FW: Subject: ACP-324165-26 - Response to Section 4.3.2 - Christian Ahles

RESPONSE TO SECTION 4.3.2 (NATURE CONSERVATION) OF THE
APPLICANT'S RESPONSE TO OBSERVATIONS
Maughanaclea Renewable Energy Development — ACP-324165-26

Cumulative Context

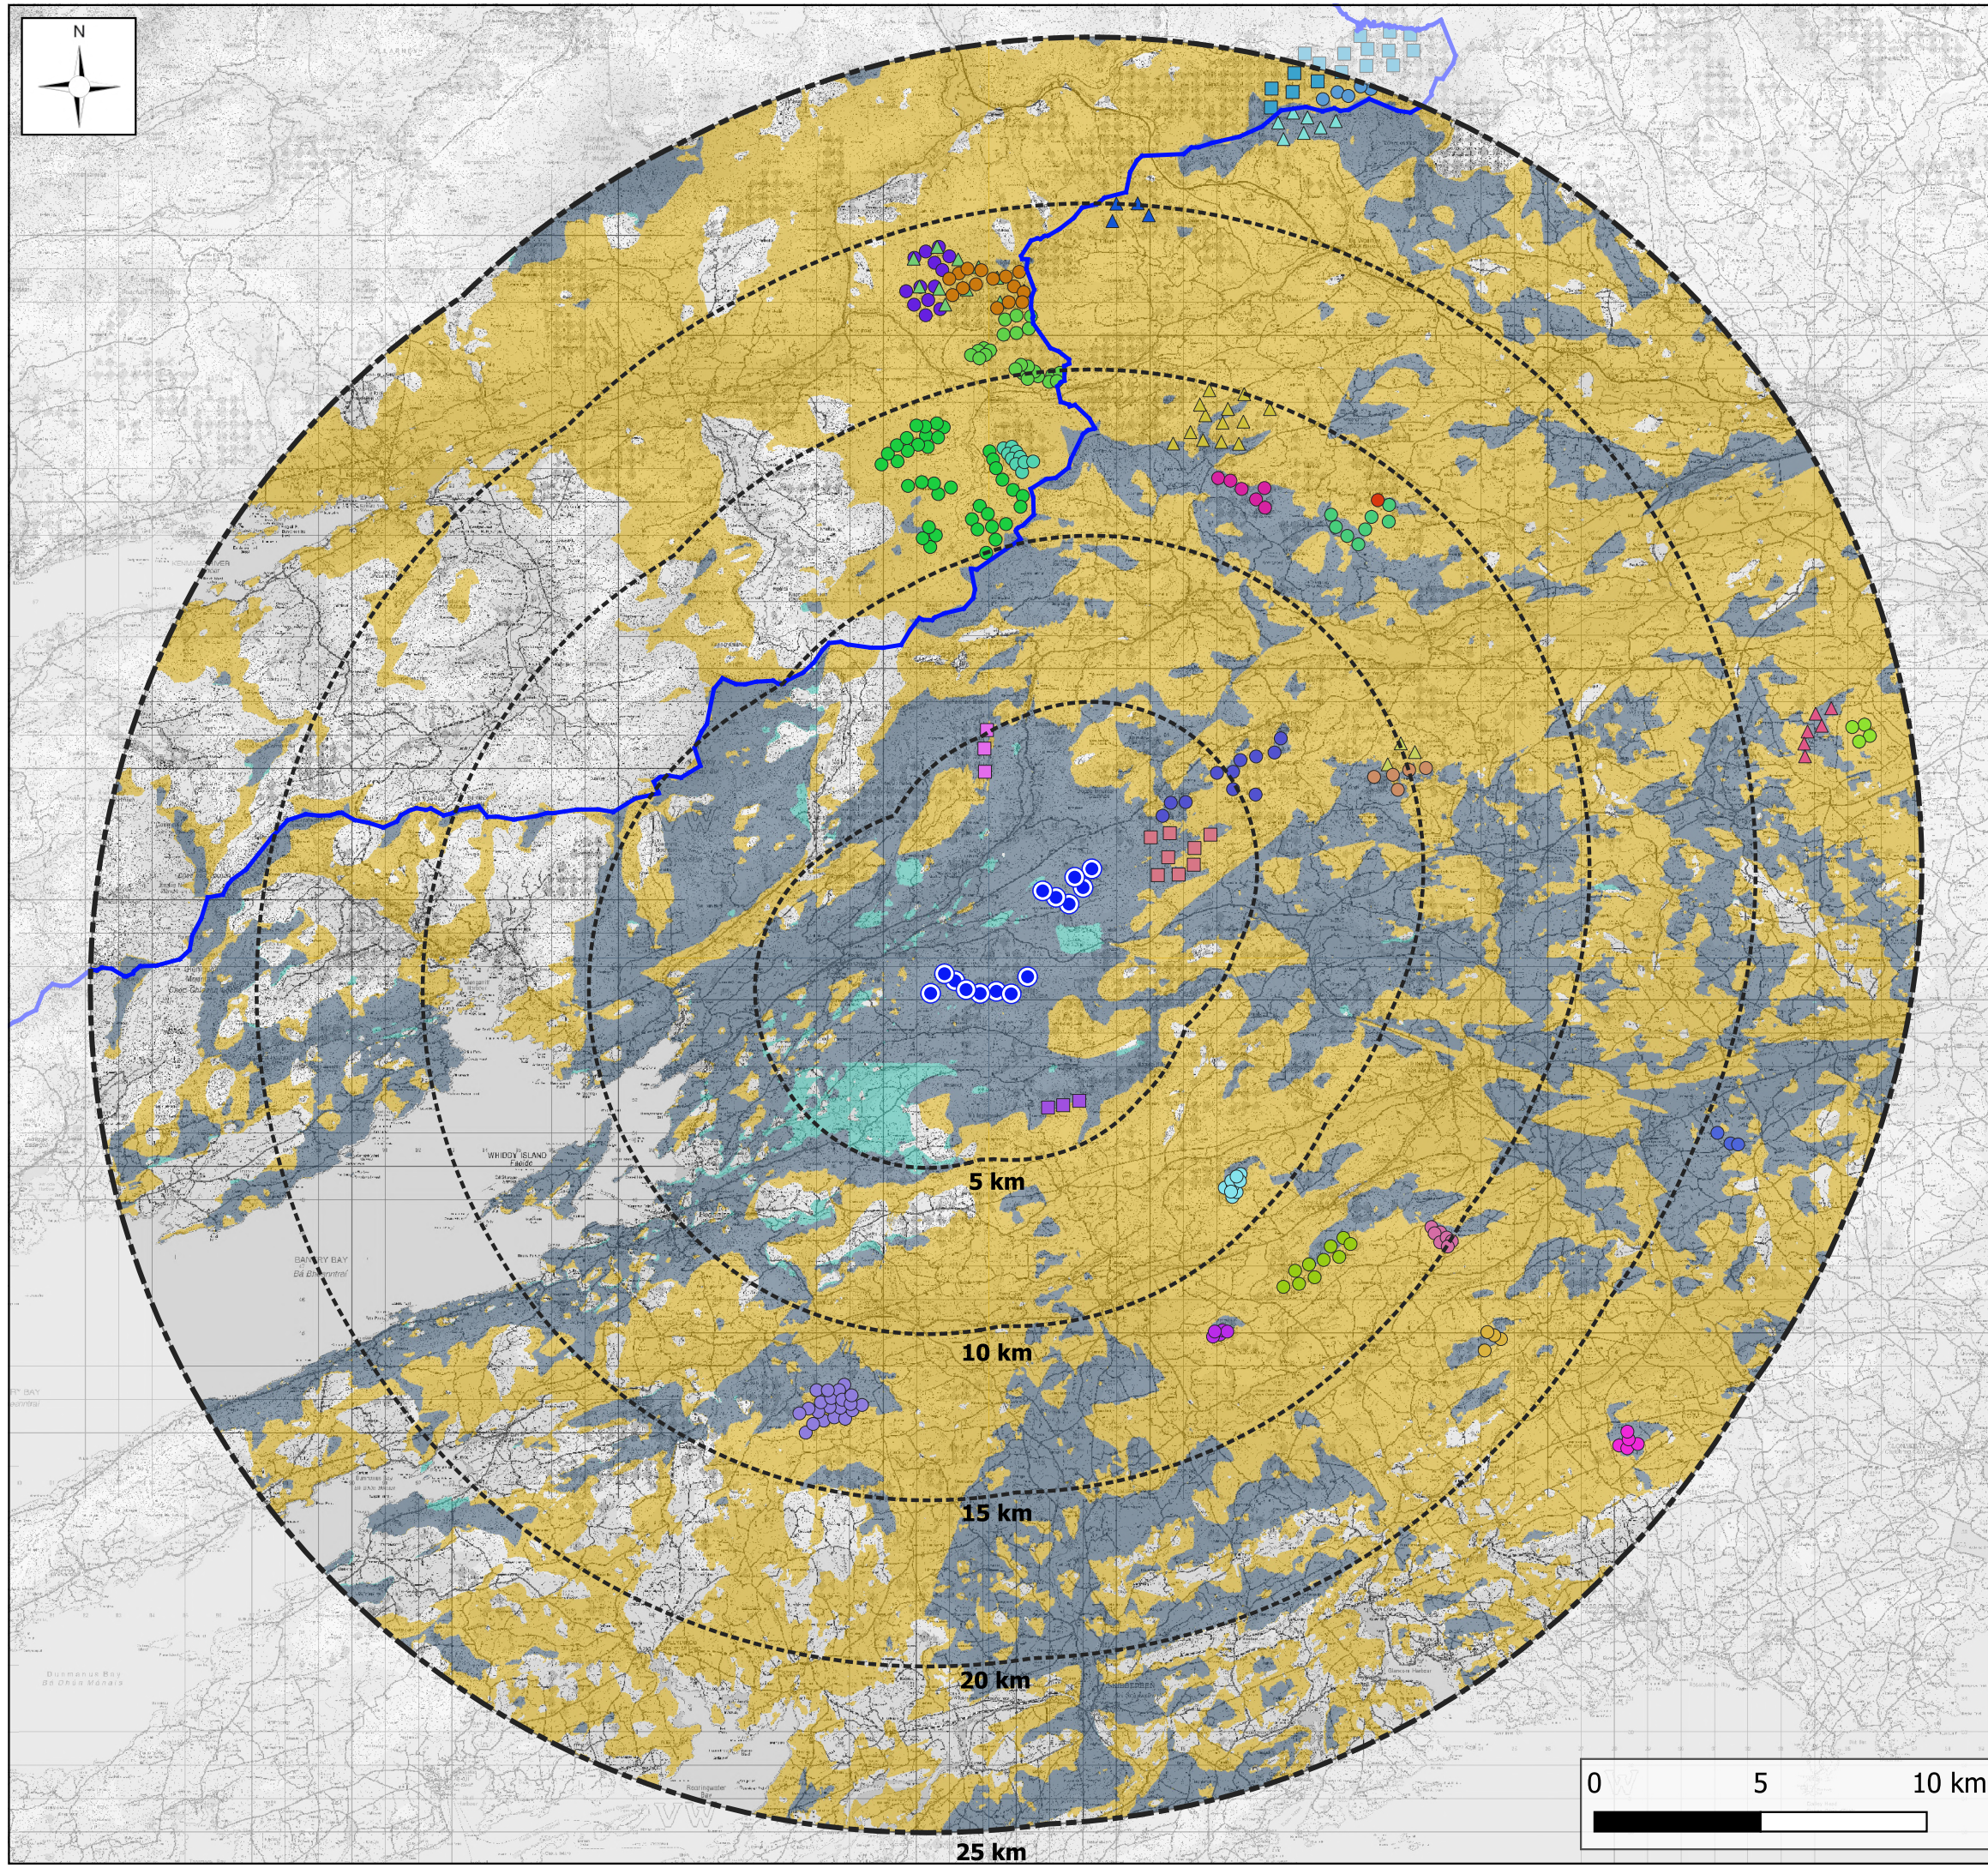
4. Yet the same Dreenacreenig West development is absent from the cumulative assessments in the EIAR's landscape chapter, its noise chapter, and its project description. The applicant cannot have it both ways. Either Dreenacreenig West is a relevant cumulative development — as its own Response to Observations now accepts, six times over, in the bird assessments — or it is not. A development real enough to count for snipe and buzzard is real enough to count for landscape and noise. This contradiction is supplied entirely by the applicant's own documents, and it means the environmental assessment before the Commission is not internally consistent.
